## WEST SUSSEX COUNTY COUNCIL CONSULTATION

| <b>FROM:</b>                    | WSCC - Highways Authority                                                                                                                                                                                                                     |
| <b>LOCATION:</b>                | 14 Princess Avenue<br>Bognor Regis<br>PO21 2QT                                                                                                                                                                                                |
| <b>SUBJECT:</b>                 | AW/251/20/OUT<br><br>Outline application with some matters reserved (landscape reserved) for the proposed conversion of existing dwelling into 4 No. flats including single & two storey rear extensions & first floor extension over garage. |

Proposed Site Layout Plan at 1:100 scale

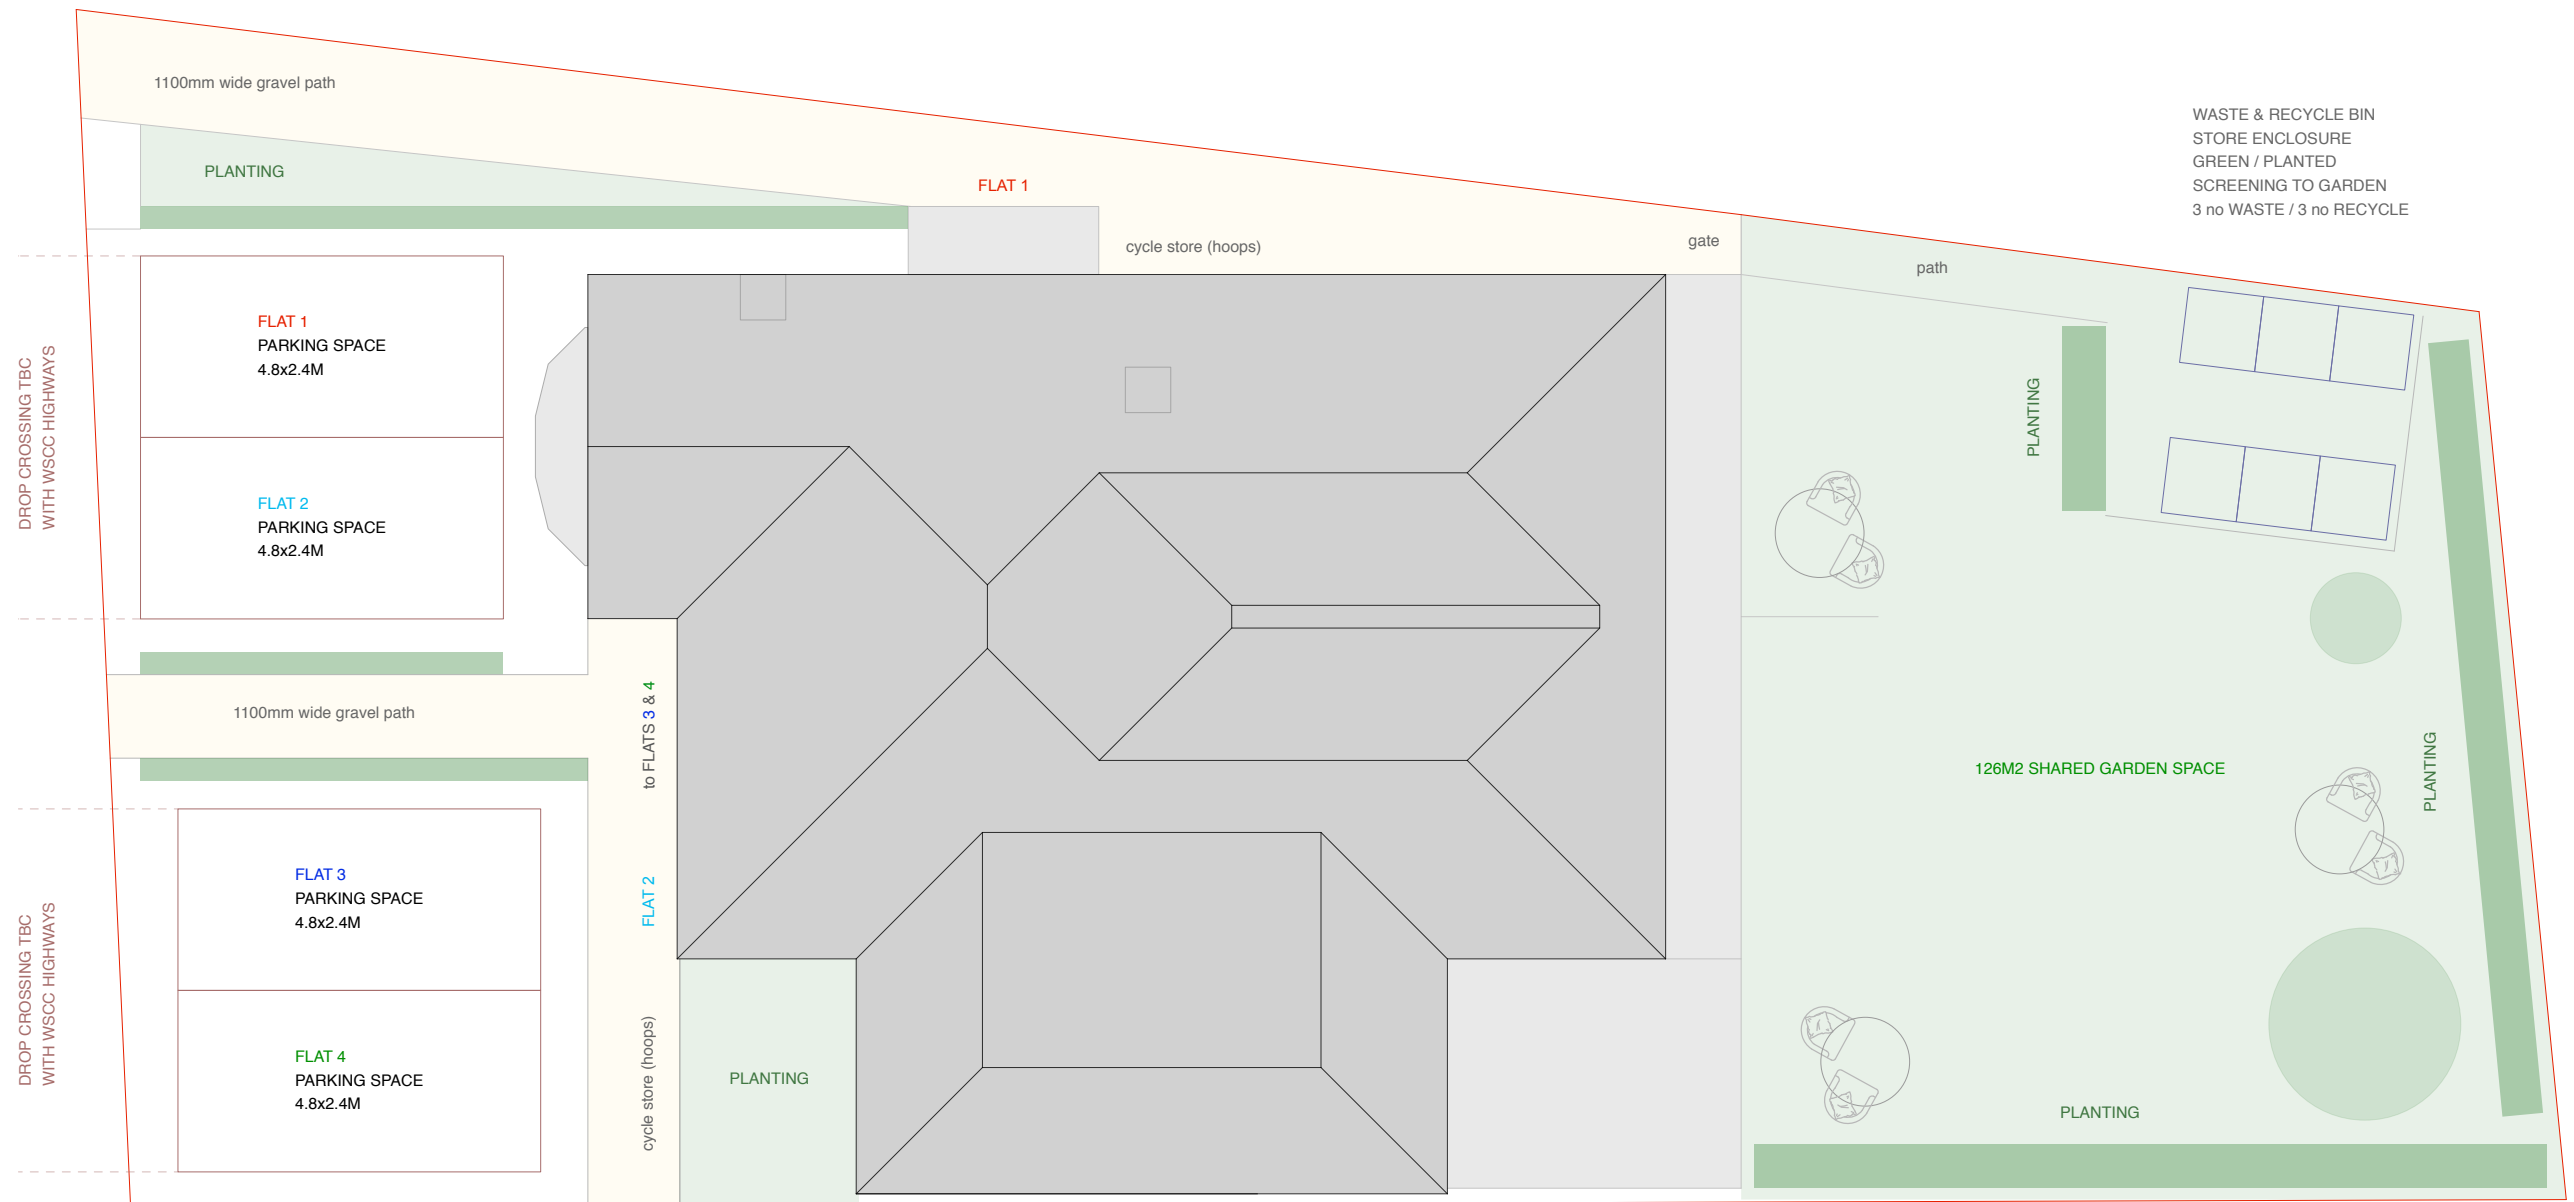
The proposed site plan demonstrates a 1.1m gravel path adjoining the public footpath. It should be noted that a gravel trap or other bound material should be provided where the access adjoins Princess Avenue to prevent the material being dispersed onto the public highway. The gravel trap must be positioned within the applicant's land and not the publicly maintained highway.

Onsite parking provision of four spaces is proposed to serve the new development. One parking space will be allocated to each flat. WSCC Car Parking Demand Calculator (PDC) would expect two parking spaces to be provided for the one-bedroom flats, and four parking spaces for the two-bedroom flats, resulting in likely overspill of two parking spaces. Each parking space accords with the minimum requirements of 2.4 x 4.8m as outlined in Manual for Streets (MfS) guidance.

In order to promote the use of the sustainable transport methods, covered and secure cycle storage should be provided for the new flats. The proposed site plan annotates cycle store hoops style and these details are acceptable.

No development shall be first occupied until the vehicular access serving the development has been constructed (including a bound material from the back edge of the Highway boundary to prevent gravel overspill) in accordance with the approved Site Layout Plan.

No part of the development shall be first occupied until covered and secure cycle parking spaces have been provided in accordance with the approved Site Layout Plan.

No part of the development shall be first occupied until the car parking has been constructed in accordance with the approved Site Layout Plan. These spaces shall thereafter be retained at all times for their designated purpose.
